Timbers of Black Forest Subdivision No. 1

Final Drainage Report

PCD File No: **SF2616**

July 2026

PROPOSED DRAINAGE MAP

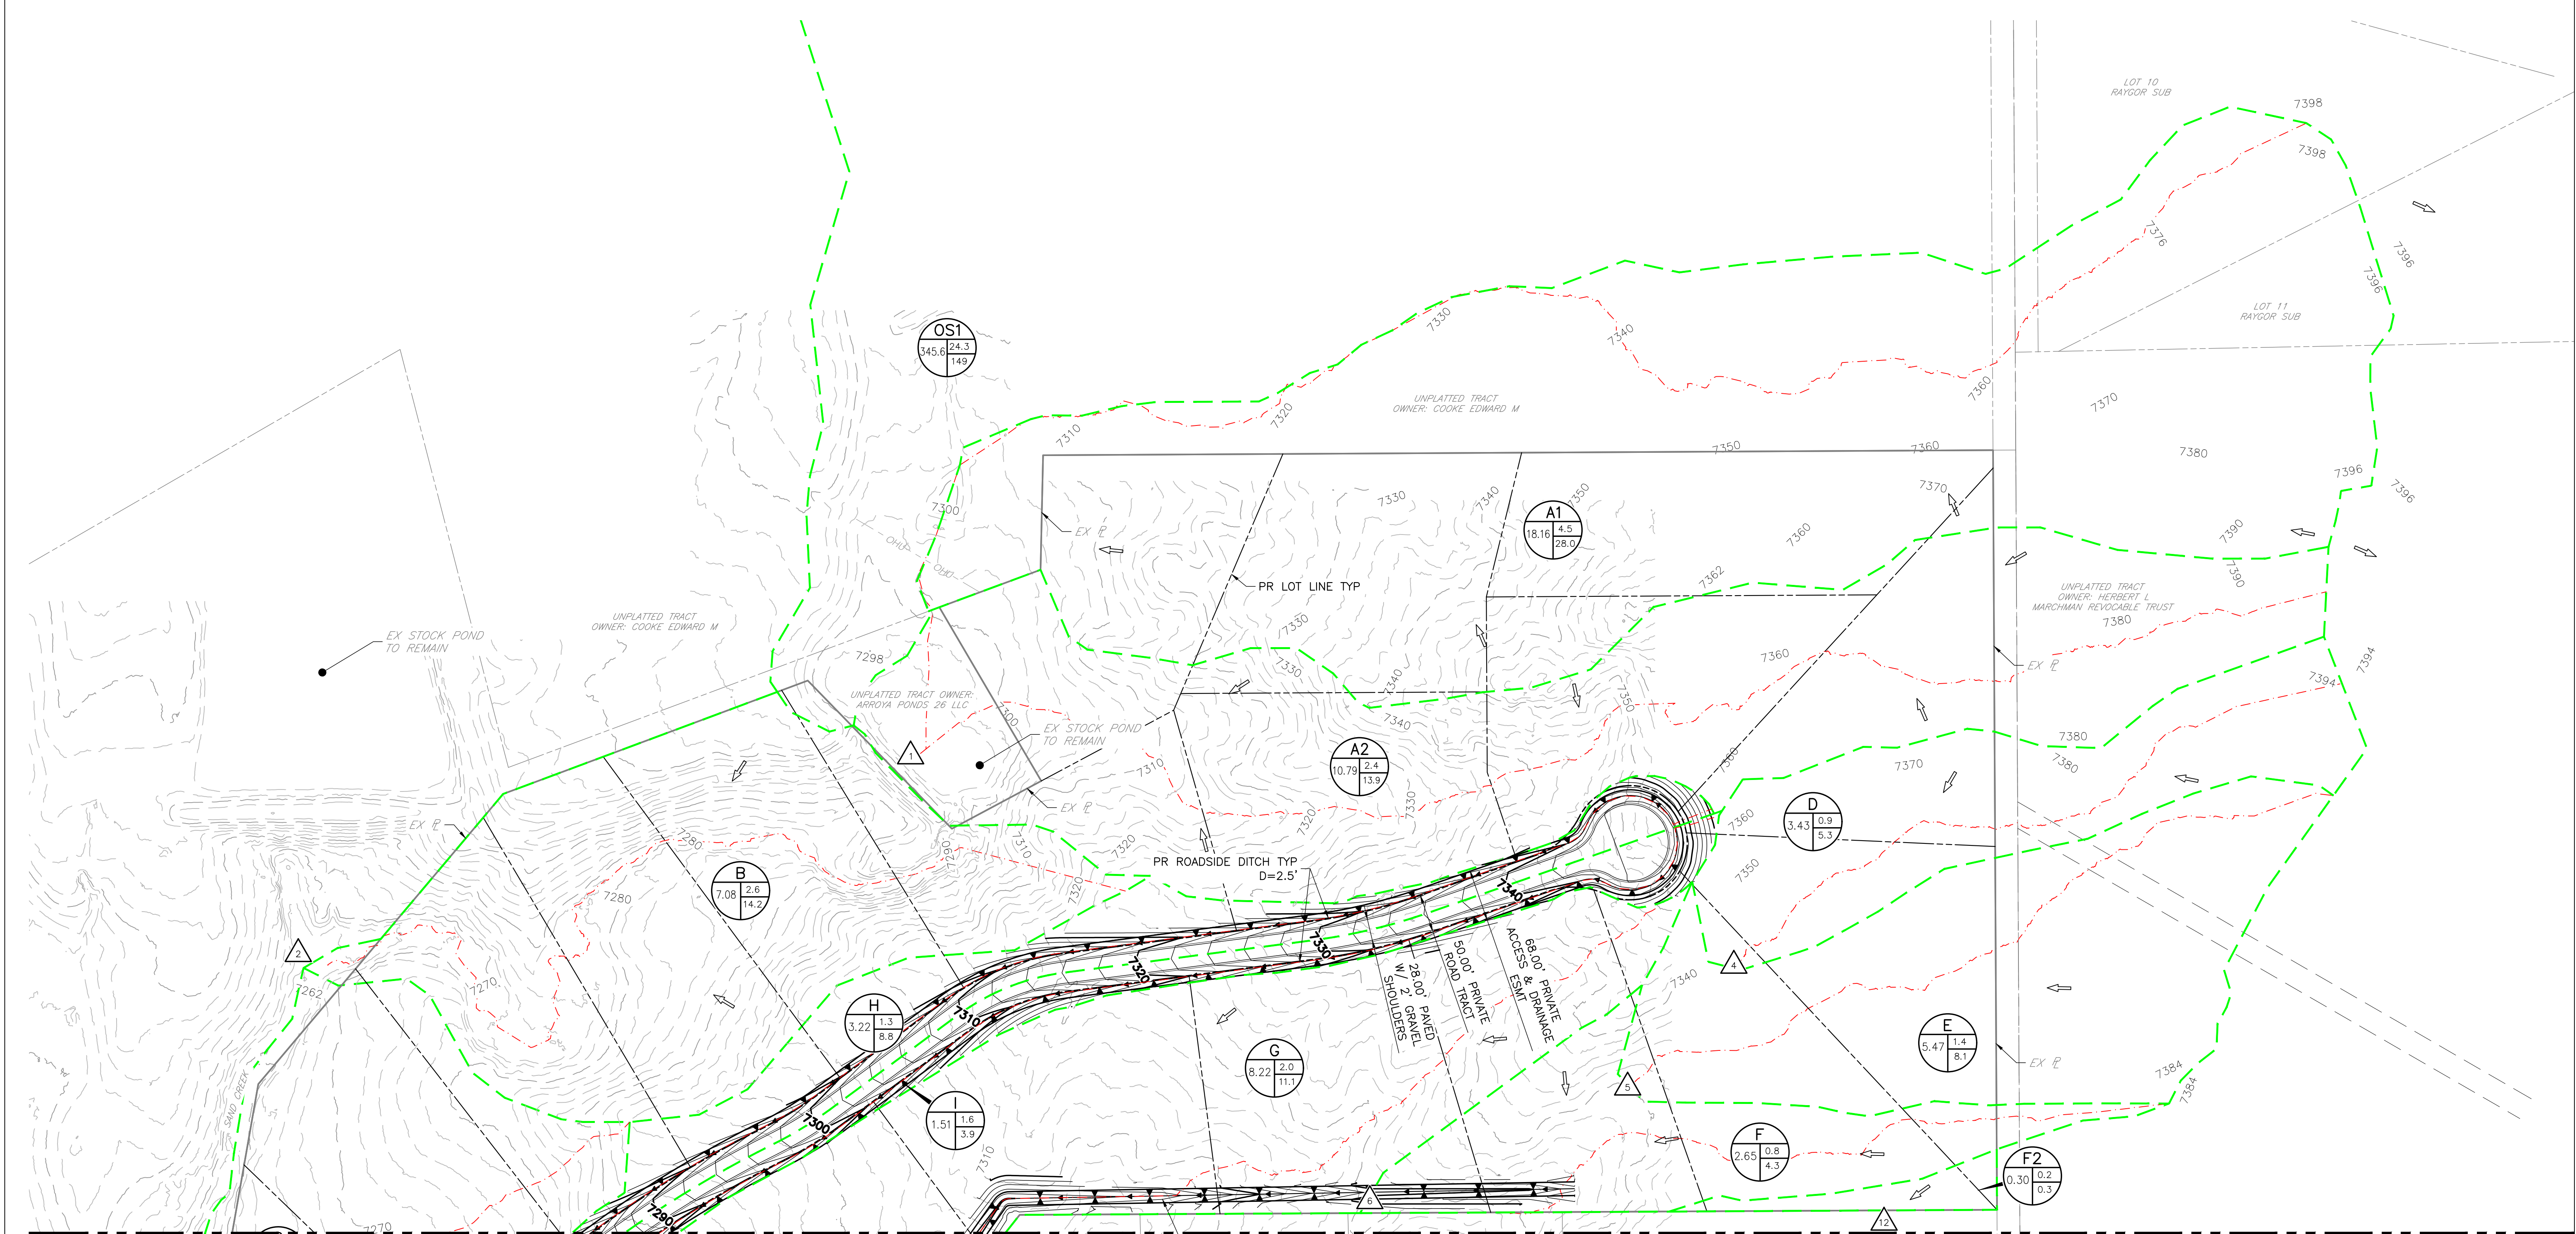
What happens if stock pond fails? Provide analysis of full undetained flow through swale and show limits of what 100 yr water surface could be. Provide small write up detailing this.

If Basins A1, A2 & B go to the stock pond, where is water quality being provided for these basins?
